From: manjinder.sehmi@hertfordshire.gov.uk
Sent: 05 April 2018 14:40
To: Planning
Subject: Planning application 6/2018/0688/PN11 - Andre House

Response to Planning application from Hertfordshire County Council (T and CP GDP Order 2015)

Andre House
19-25 Salisbury Square
Hatfield
AL9 5BT

Prior approval for change of use of site and building from offices B1(a) to dwellinghouses (C3) to include the creation of 9 residential units

[02] BLOCK PLAN 1:200 @A3

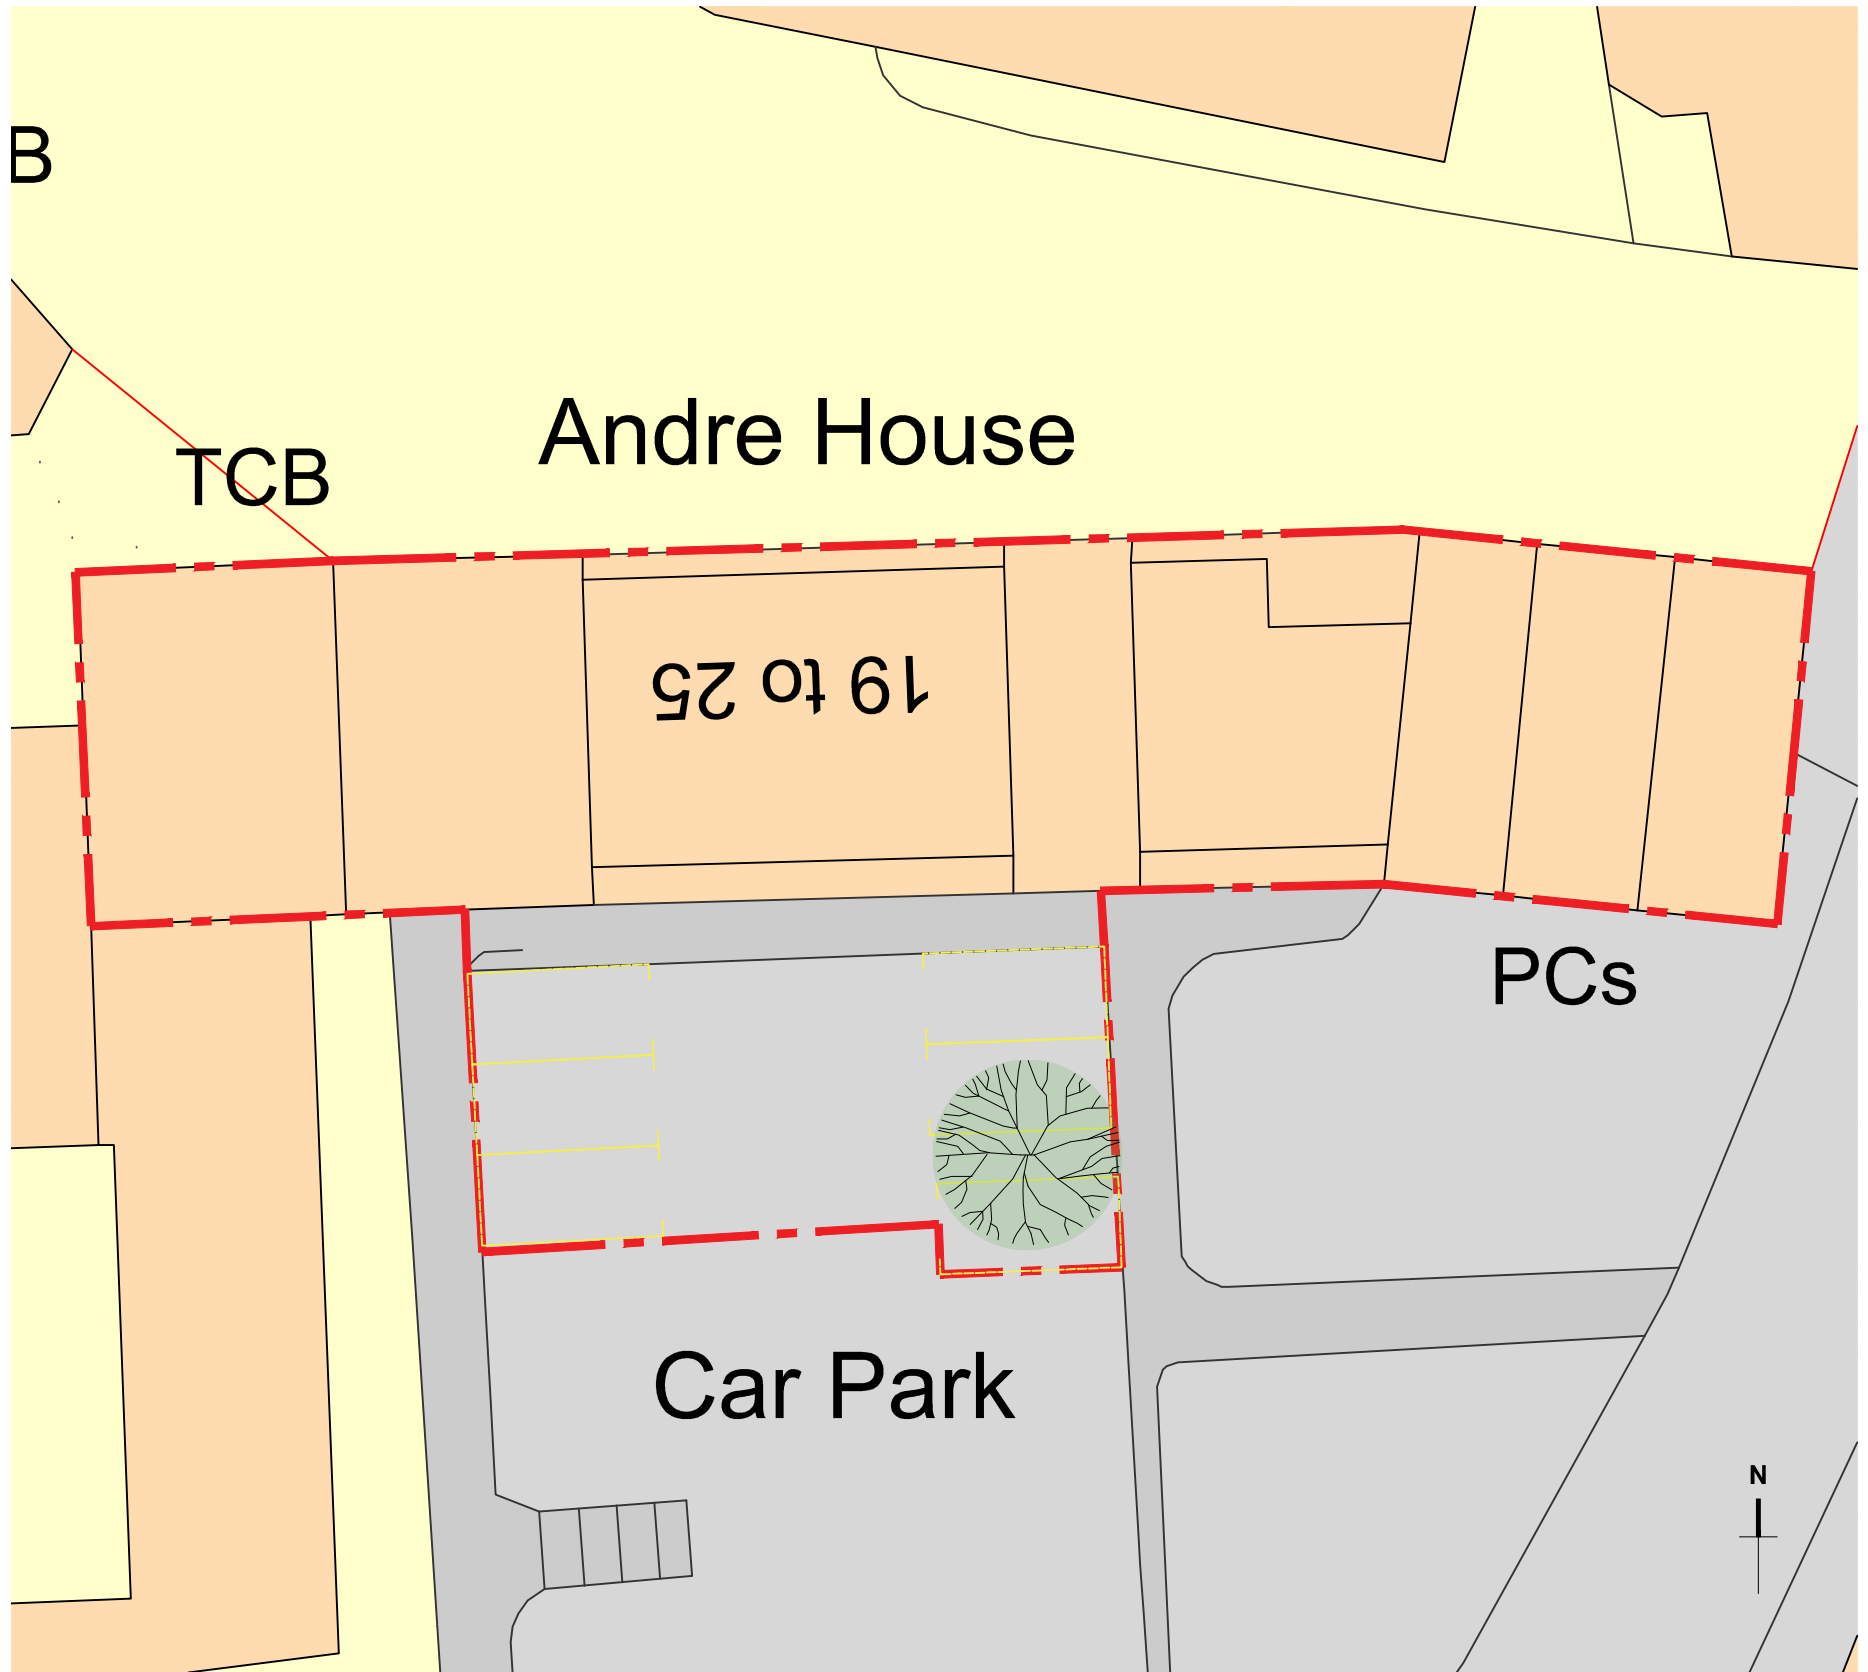
Accessibility arrangements appear to remain unchanged from the existing office use, with all parking provision of 6 spaces laid out to acceptable and suitable dimensions. It is recommended that the LPA consult the relevant emergency services with regard to access arrangements.

The site is at a sustainable location. It is however unclear if bicycle parking is provided, but would be achievable and recommended. Access to other sustainable forms of transport is directly adjacent to the site at Hatfield Station.
